Re: Formal Objection – Cooloo Wind Farm Application and EIAR (2025) - 323761

Technical Review Report – Chapter 8: Land, Soils & Geology (Cooloo Wind Farm EIAR)

Figure 8-4 Site Investigation Map

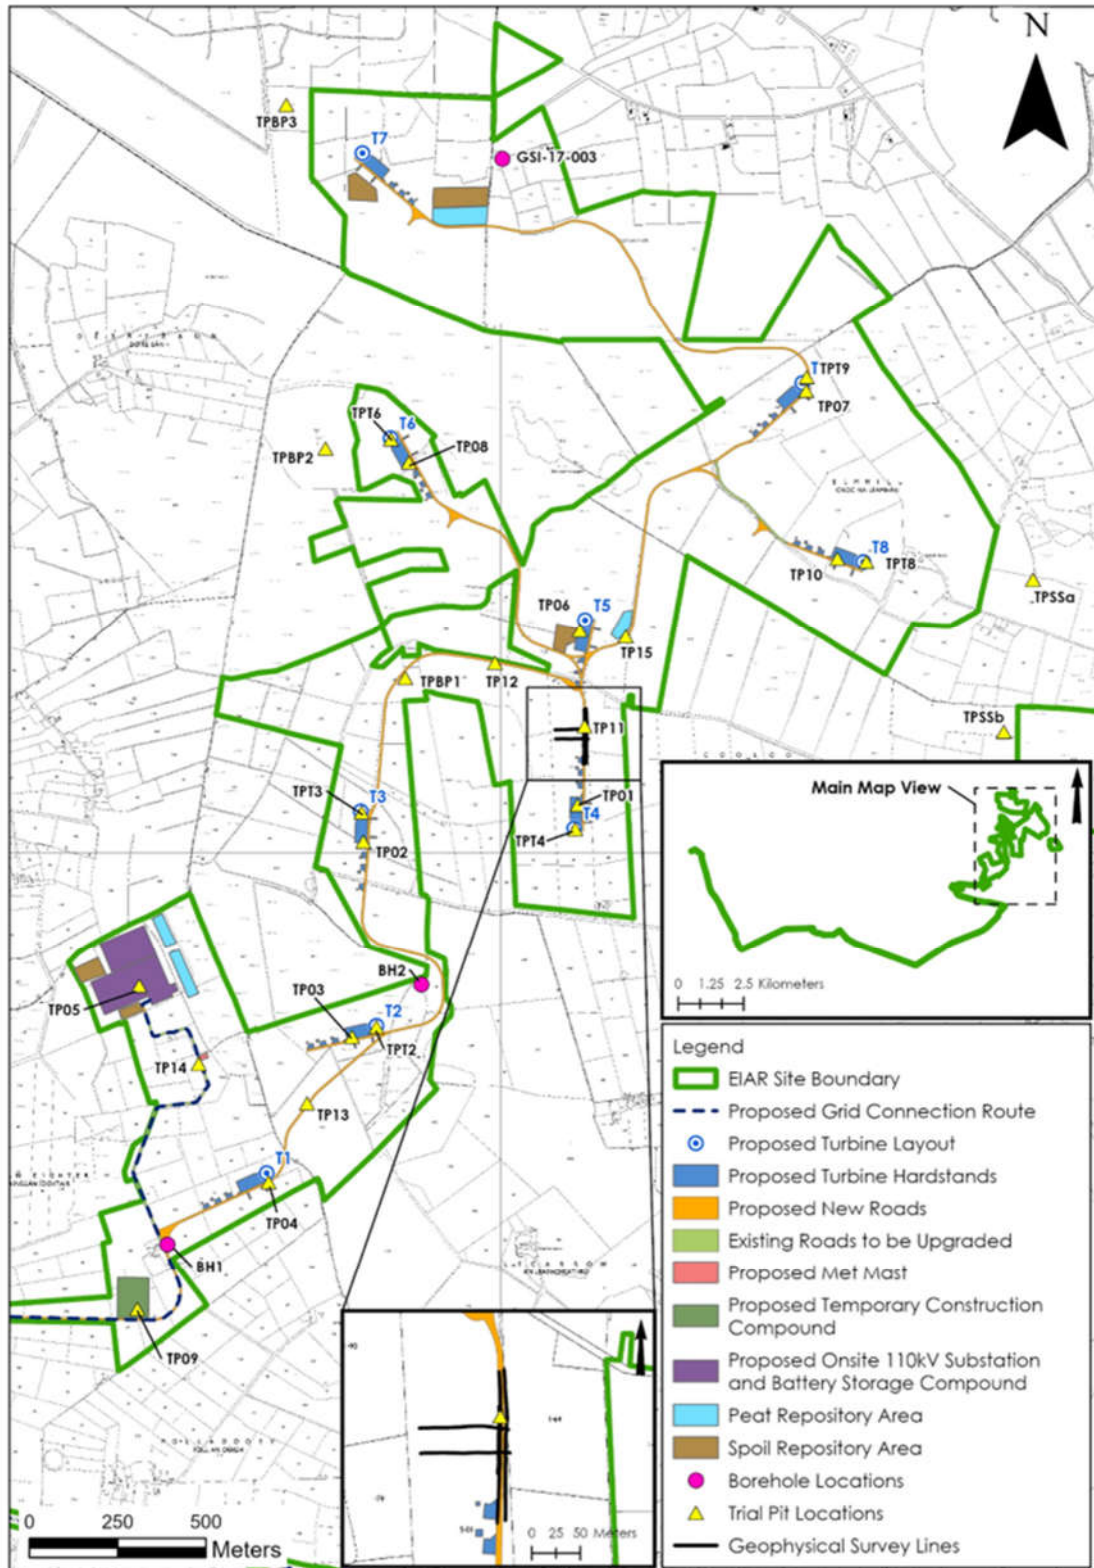
The investigation included 26 trial pits, 2 boreholes, over 300 peat probes, and limited geophysics (4 ERT and 1 seismic line). Data are clustered around turbine locations, leaving roads, trenches, and peripheral slopes under-sampled. Laboratory testing was limited to hand shear vane and moisture content—no ring-shear or consolidation testing.

Issue	Critique / Objection	Comment
<p>Survey sufficiency: spatial & depth coverage</p>	<p>While 306 peat probes, 26 trial pits, and 2 boreholes are used, that may still be insufficient sampling density in areas of high risk (deep peat, slope transitions). The boreholes are only two — that is low for a project of this scale.</p>	<p>“The Chapter 8 investigation relies on only two boreholes for deep subsurface stratigraphy in a 9-turbine site, which is inadequate given the varying peat depths and subsurface complexity. The sampling density is insufficient in key areas (e.g. near turbine bases, along access roads crossing bog) to establish confidence in peat / geotechnical stability.”</p>
<p>Uninvestigated peat under grid route</p>	<p>They state that along the public road section of the grid cable route, peat was <i>not</i> investigated. This is a gap: the grid connection passes over areas where peat is possible, but they did not test it.</p>	<p>“It is unacceptable that no peat probing or subsoil investigations were carried out for the public road portion of the grid route. The assumption of no peat there is unverified, and risk of unexpected peat / soft ground conditions must be ruled out.”</p>

Figure 8-7 GDG Karst Feature Mapping

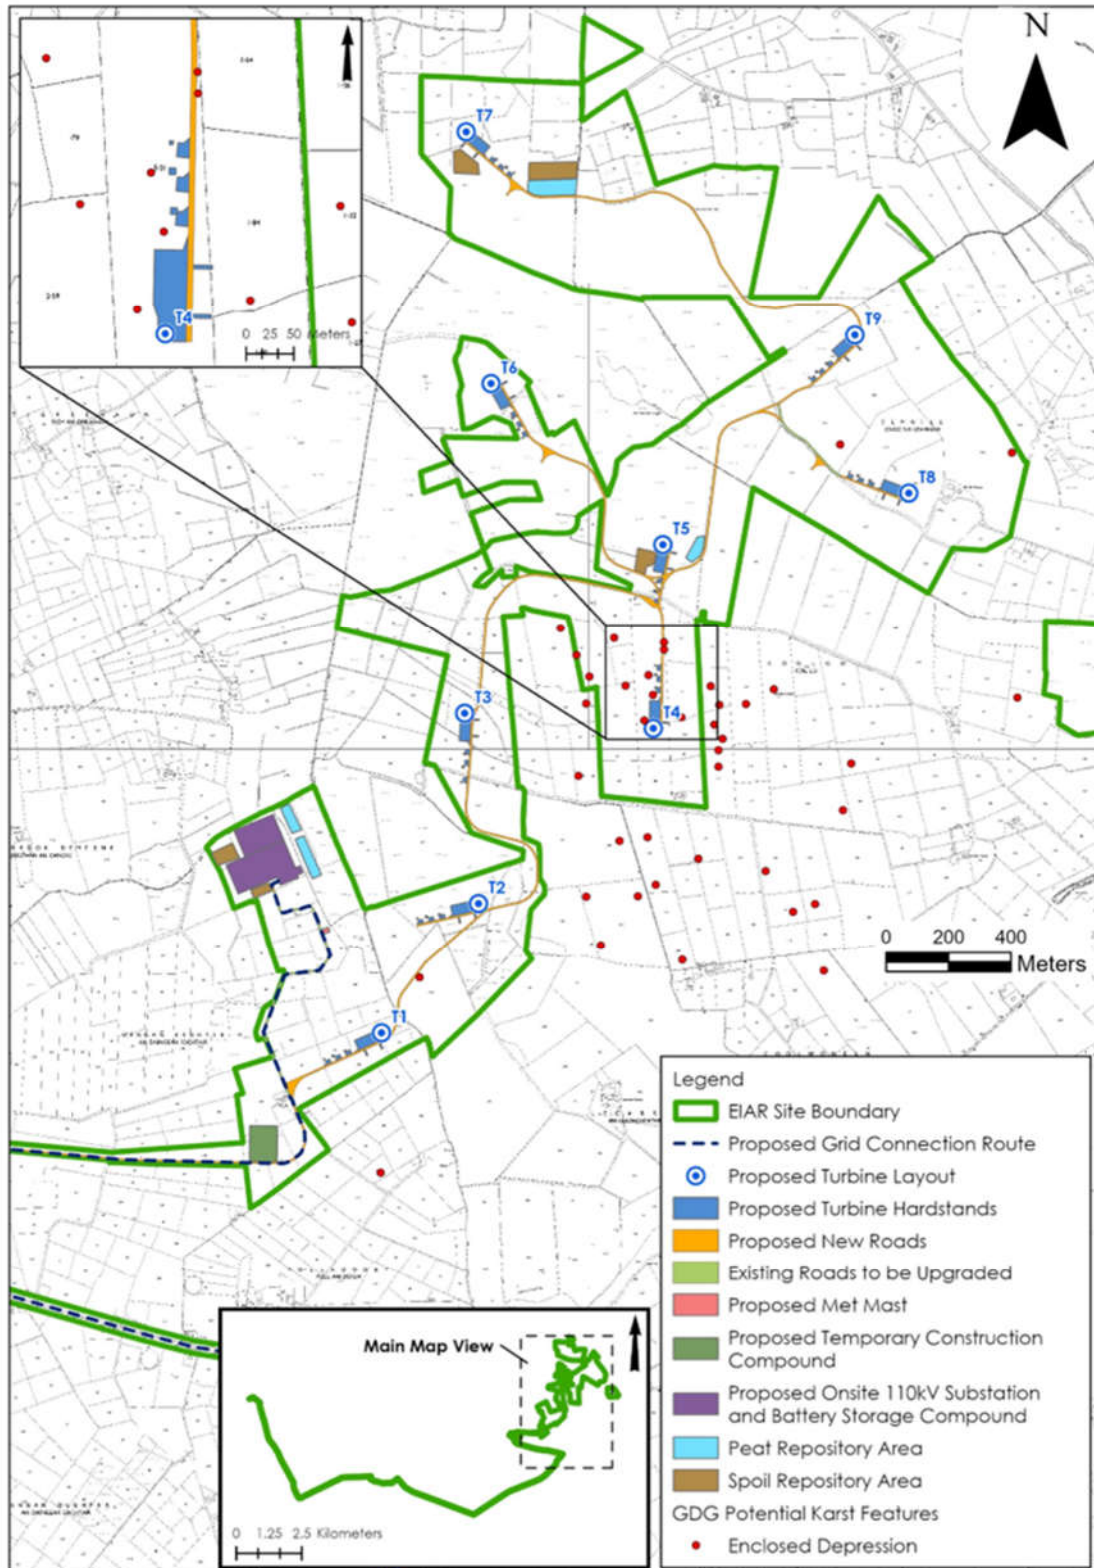
The KRA applies a qualitative risk matrix (Rutty & Jennings 2012). Bedrock is within 5 m bgl across much of the site, and several doline features remain unconfirmed. Risk downgraded to 'low-medium' after applying generic mitigation (piling, grouting), without quantitative validation or hydrogeological linkage to the Lough Corrib SAC.

Issue	Critique / Objection	Comment
<p>Karst / enclosed depressions: mapped but not fully assessed</p>	<p>They have identified 11 potential enclosed depressions within the site (especially near turbine T4). These are near sensitive infrastructure and need robust assessment.</p>	<p>"Although 11 potential enclosed depressions were mapped inside the site boundary, the EIA downplays their significance and does not provide sufficient detailed subsurface investigation within these depressions. Some may act as conduits for water, or suggest hidden voids or fracture zones. The risk is under-assessed."</p>
<p>Overconfidence in absence of karst features</p>	<p>They conclude no epikarst or karstification evidence was found in the geophysical lines, and that the limestone is impure/argillaceous (less prone to karst). But geology is variable and fractures/conduits may exist off the narrow survey lines.</p>	<p>"The conclusion that no karst features exist is premature. The surveyed lines are too few; karst systems are often discontinuous and fractural, especially in limestone. The reliance on limited lines and negative findings is overconfident. The Board should require additional wide-area geophysics and borehole / dye tracing before accepting the no-karst assumption."</p>

Figure 8-8 Geophysical Survey Locations

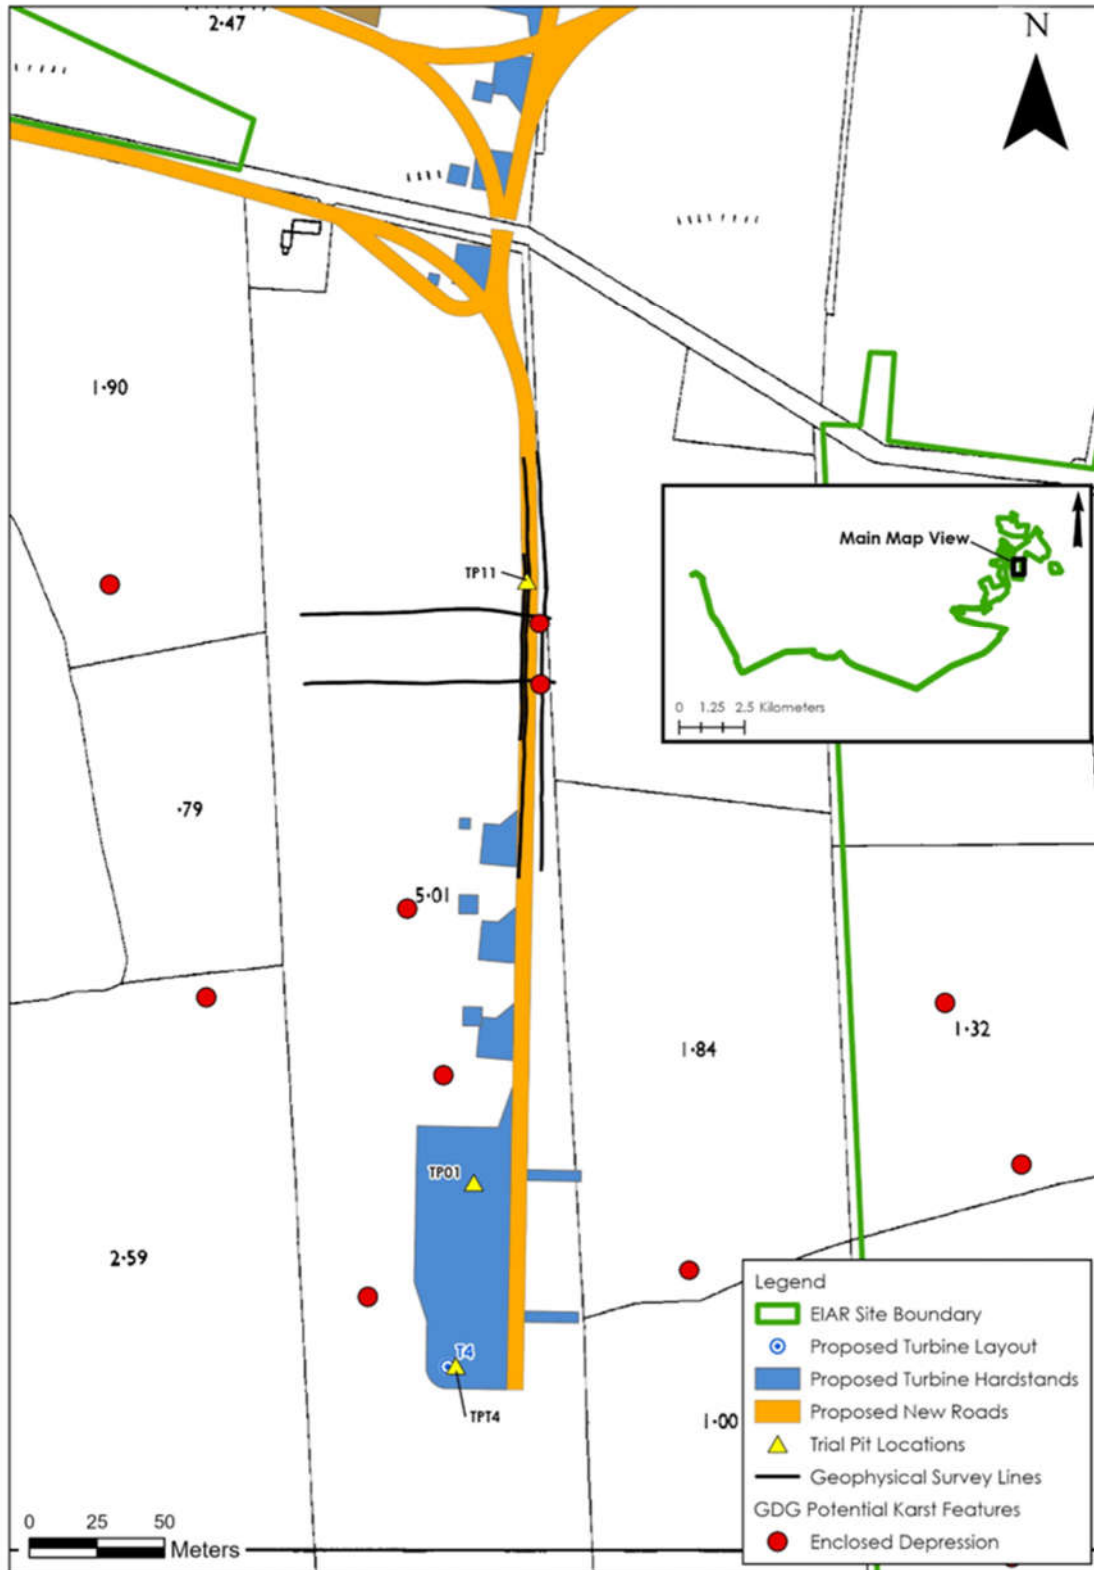
- Reliance on only two boreholes and 306 shallow probes across 9 turbines is insufficient for slope stability confidence.
- No quantitative slope-stability modelling for worst-case conditions; repeats errors of *Derrybrien (ECJ C-215/06)*.
- Peat and Spoil Management Plan defers design details to post-consent stage.
- Karst risk underassessed – limited geophysical coverage (~500 m) despite 41 mapped features.
